21 December 2020

**RIDBC Centre of Excellence (SSD-10451)
Response to Submissions**

ATTACHMENT 1

Outdoor Play Area - Section A

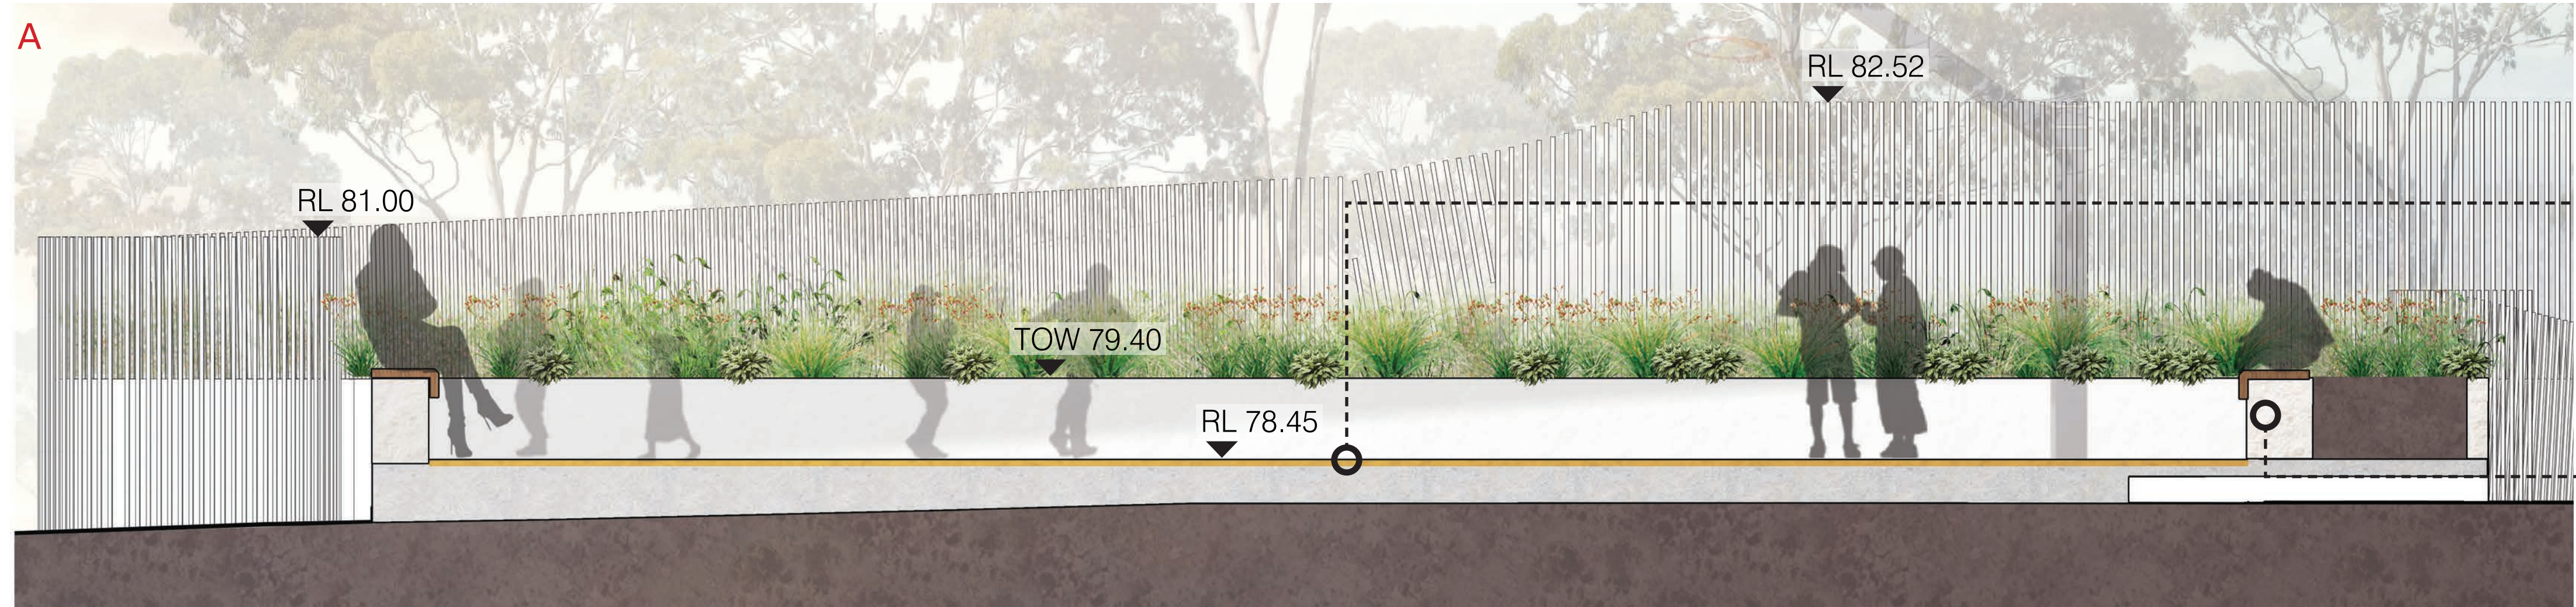
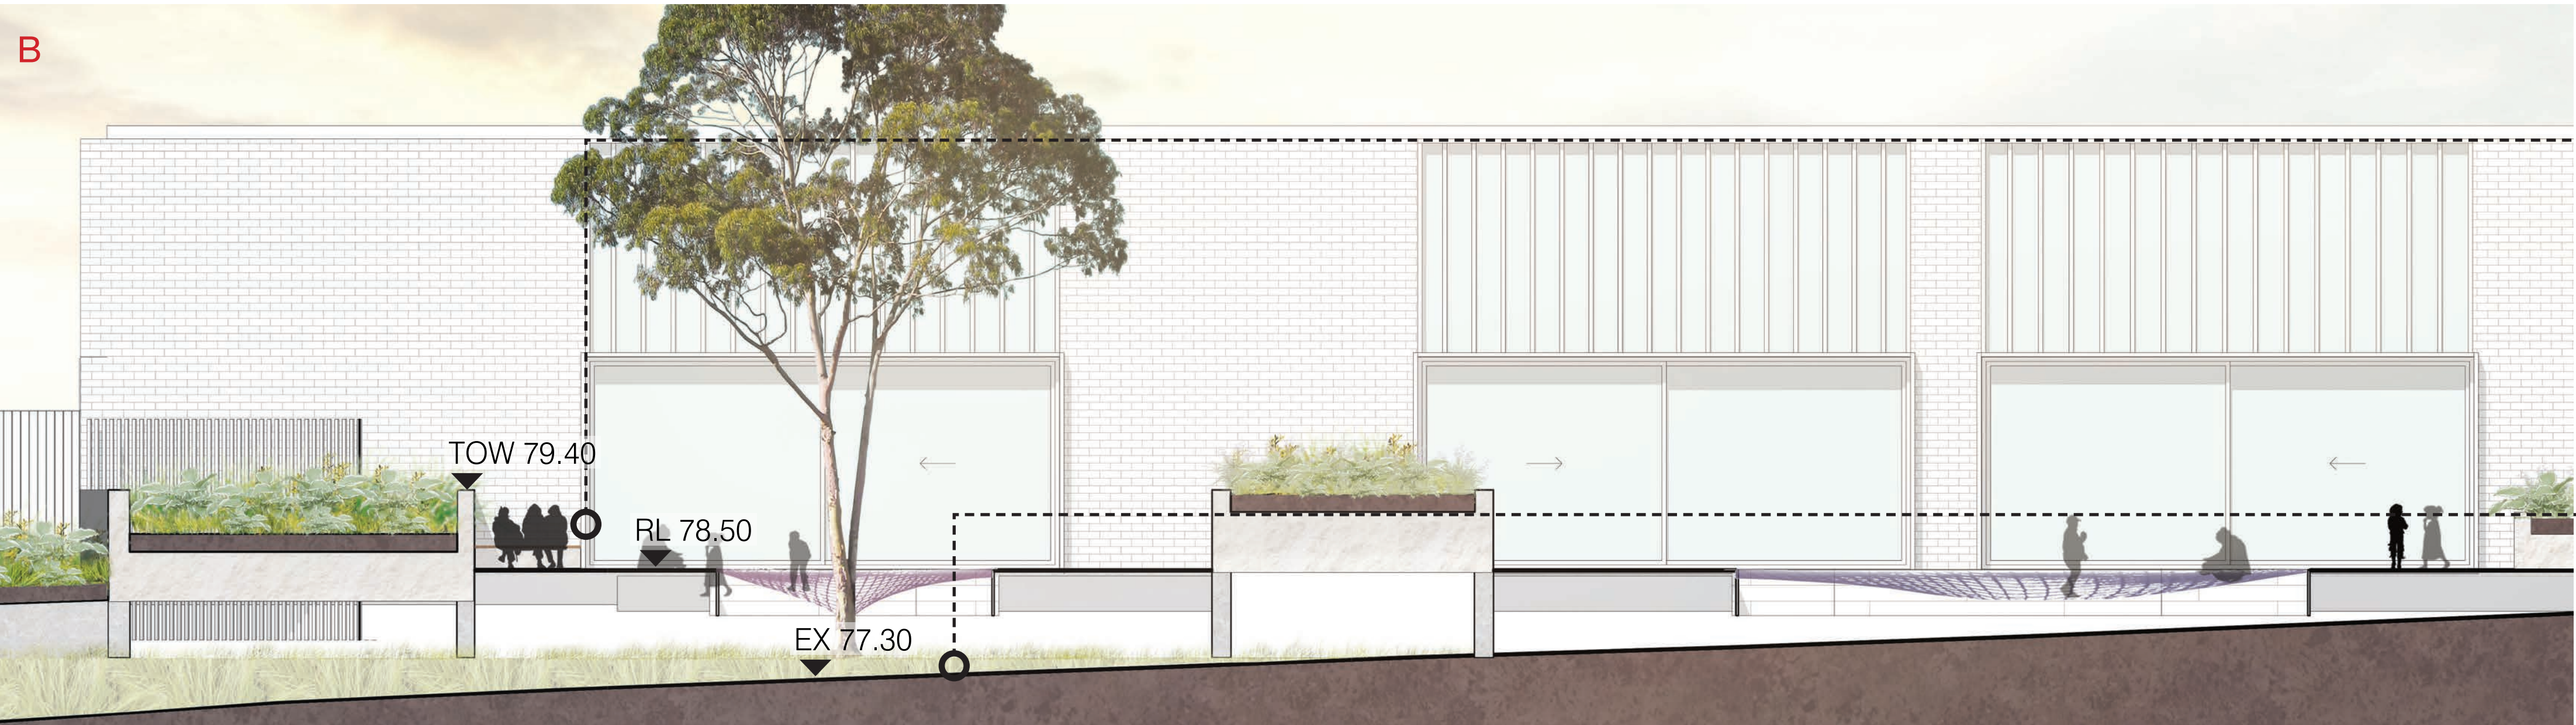
- The Department notes that the school does not include any playing/sport field, with the primary outdoor play area including hardstand surfaces (handball court, accessible netting and multi-purpose half court). The Department requires you to provide additional justification as to why there is no requirement for a formal playing field with a grass surface.
